Ask for:	Chris Spong
Telephone:	01832 742351
Planning Services	
Our Ref:	NE/21/01564/FUL
Your Ref:	PP-10292932
Date:	25 October 2021

Proposal : **Conversion of existing outbuilding to dwellinghouse; Two storey rear extension; Single storey front extension; Associated external works (including window and doors infills, new windows, doors, rooflights and gable dormer) at 8 High Street Collyweston Stamford Northamptonshire PE9 3PW .**

I refer to the above application received on **19 October 2021** but have to advise you that it is **INVALID/INCOMPLETE**. In order to enable further progress to be made, please supply the following:

Proposed East Elevation
Scale 1:100

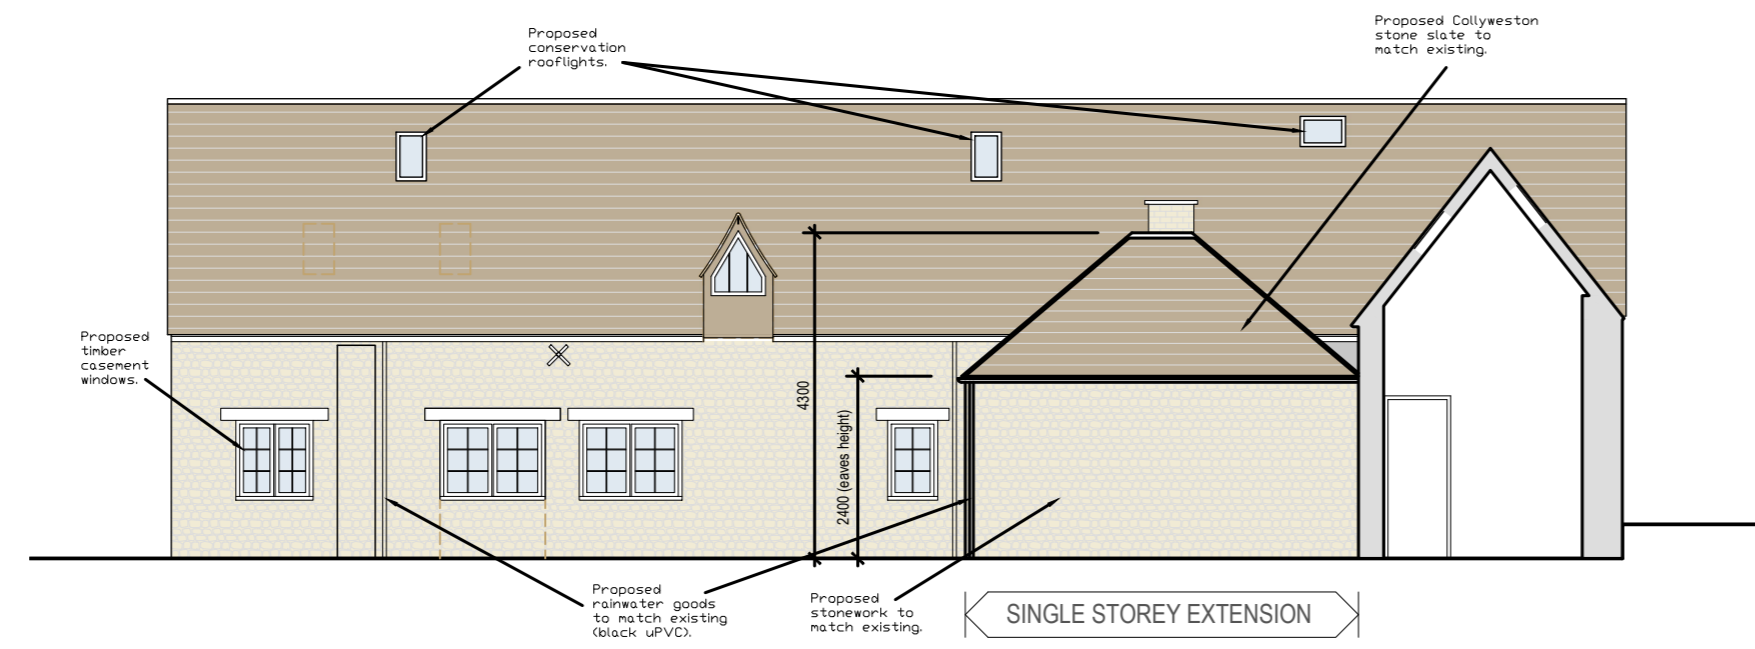
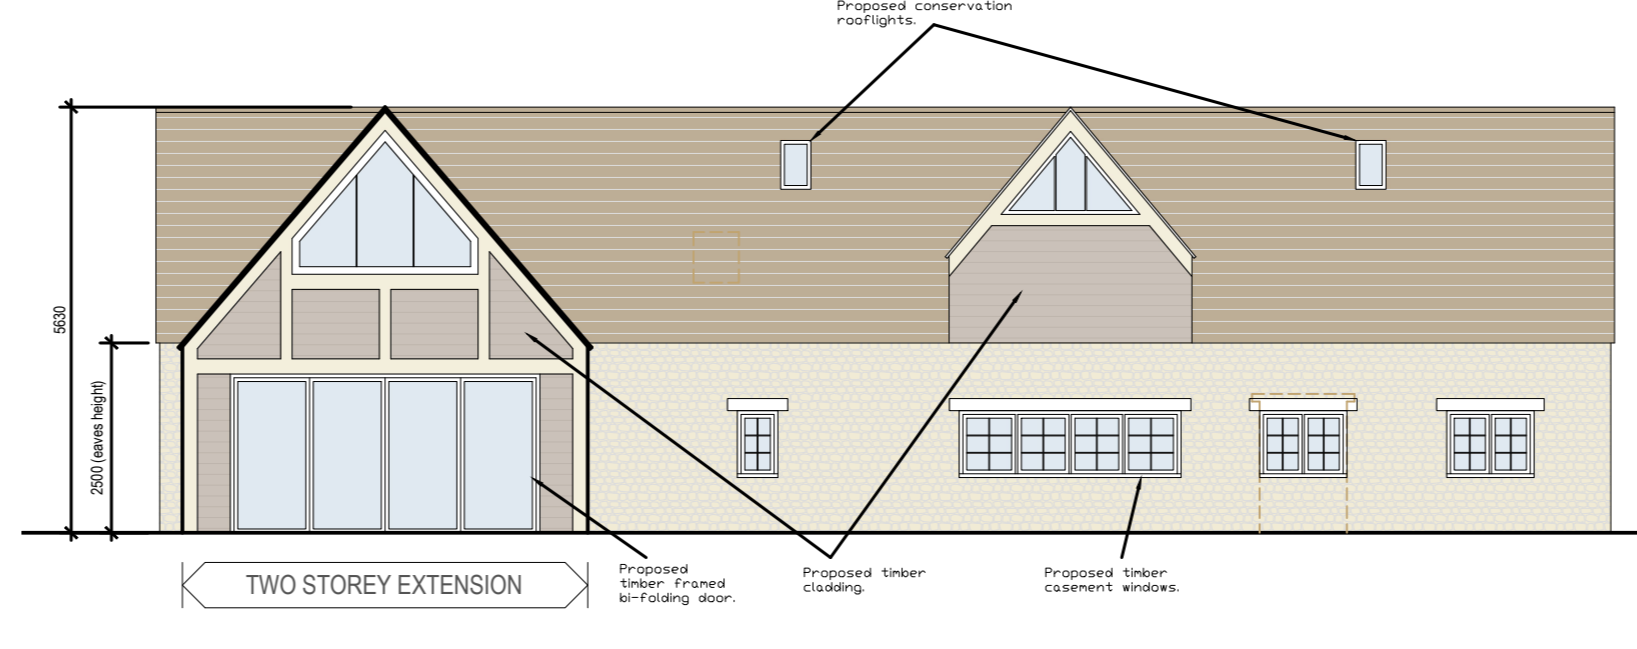
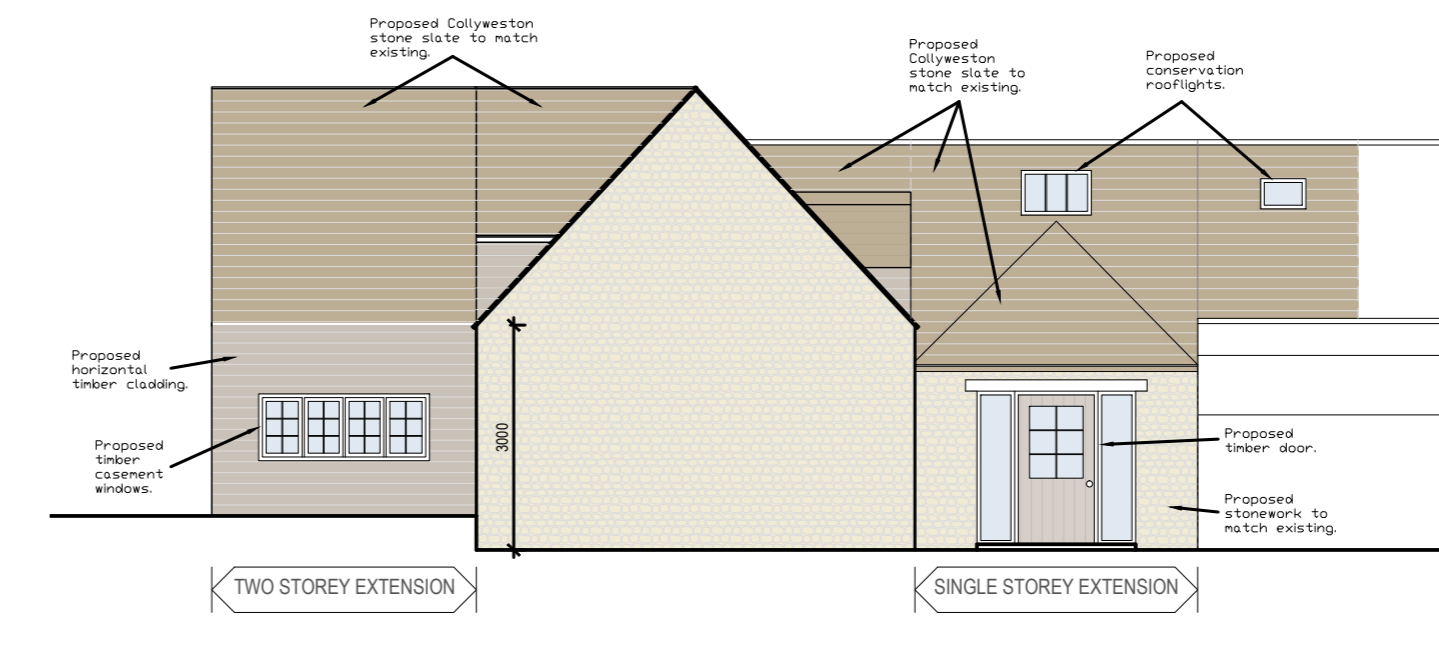
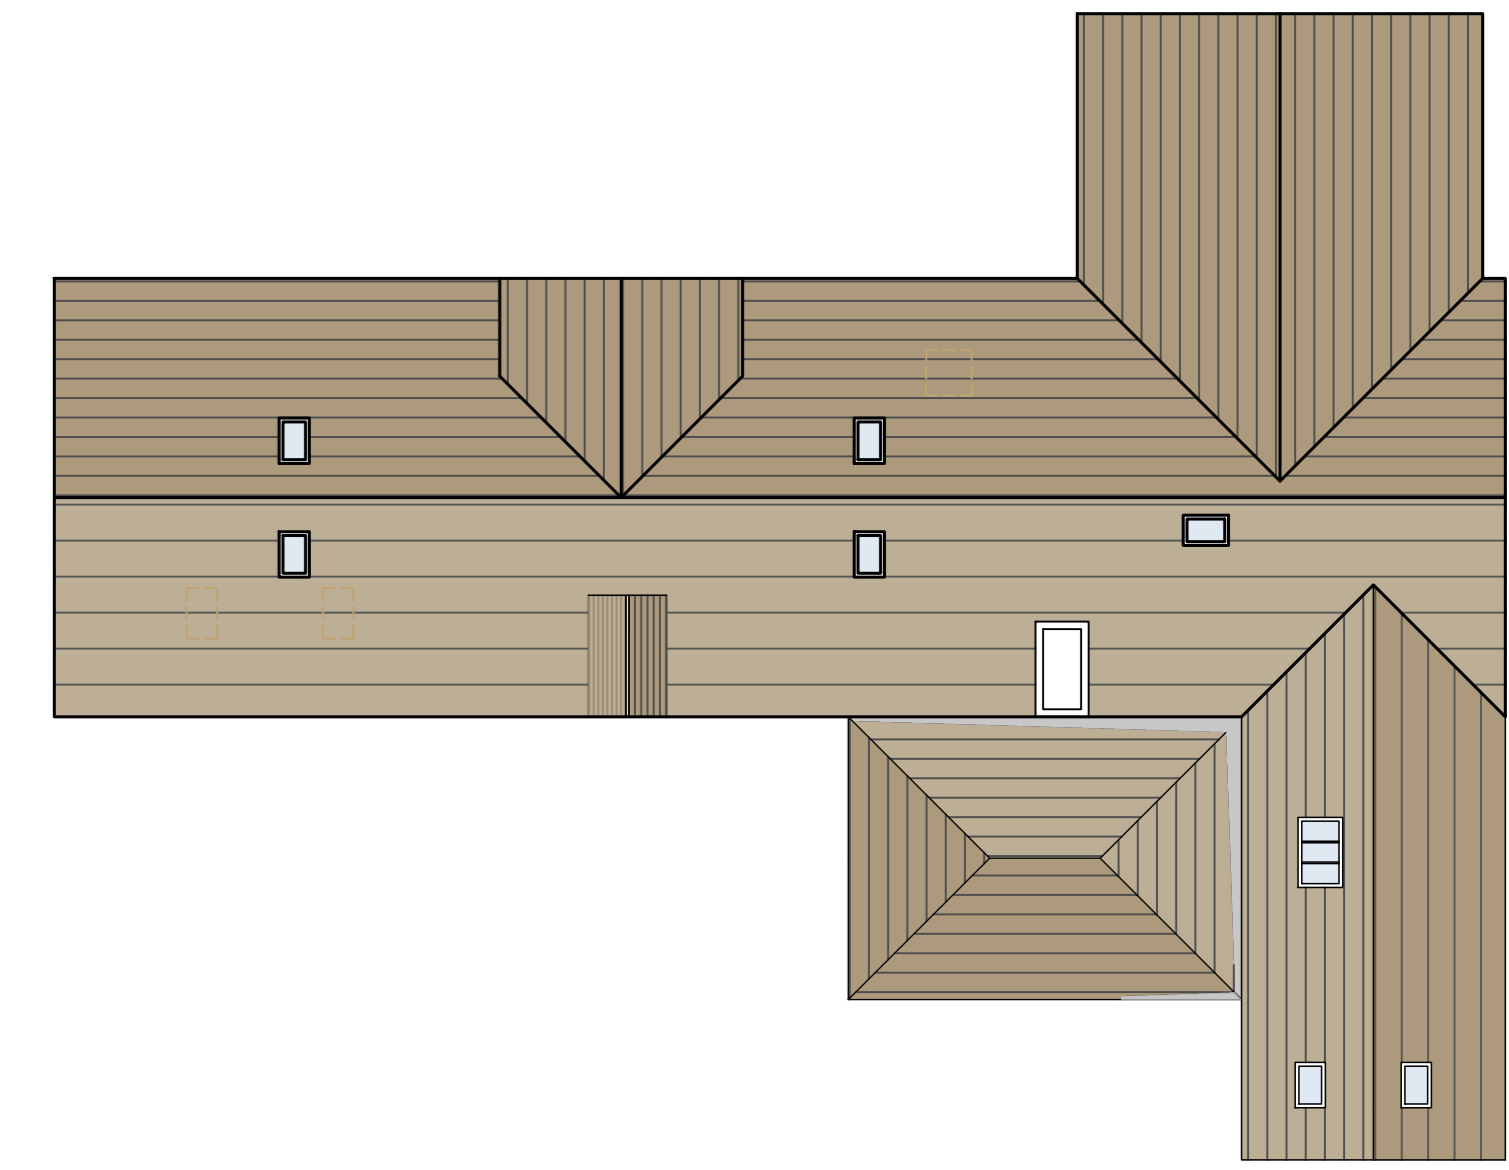
2. As per our published Local Requirements, "All plans and drawings must be drawn to an appropriate metric scale and have all relevant dimensions of the key elements of the proposal clearly written. This includes the height, length, width and (if relevant) the distance from the site boundary of any proposed works. We require this so that the proposed dimensions are clear when plans are viewed online." This is required as we now run a completely paperless planning office. Please provide amended drawings showing the height dimensions of the proposal.
